From: Martyn White
Sent: 11 September 2014 12:20
To: Simon Davis
Subject: AW/215/14/A

**ADC Planning Consultation
Response from the Conservation Officer**

Application Number	AW/215/14/A
Address	Ship Inn Aldwick Street Bognor Regis PO21 3AP
Description	3No. internally illuminated fascia signs to front and west side elevations, 1No. externally illuminated fascia sign to east side elevation and 2No. externally illuminated projecting signs to front and east side elevations.
Case Officer	Mr. S. Davis
Site Visit	9 September 2014

FRONT ELEVATION

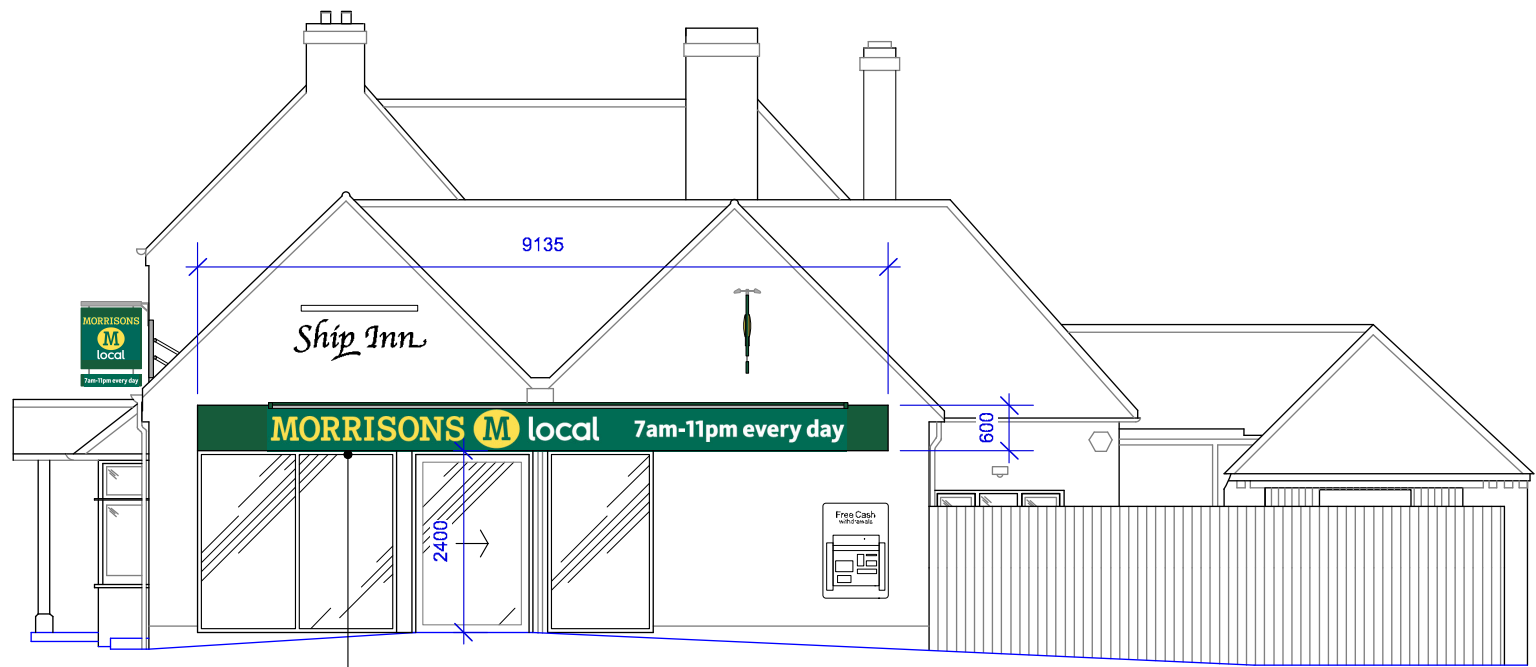
It is considered that there is an extensive amount of signage for the property. The amount, location and size of the adverts/signs create a cluttered effect. Specifically:

signs 2 and 6 (Bus stop signs) – Are these required as they mostly repeat the text in the other signs?

Sign 5 – this is a large sign. Could it be reduced to match the width of the window/door?
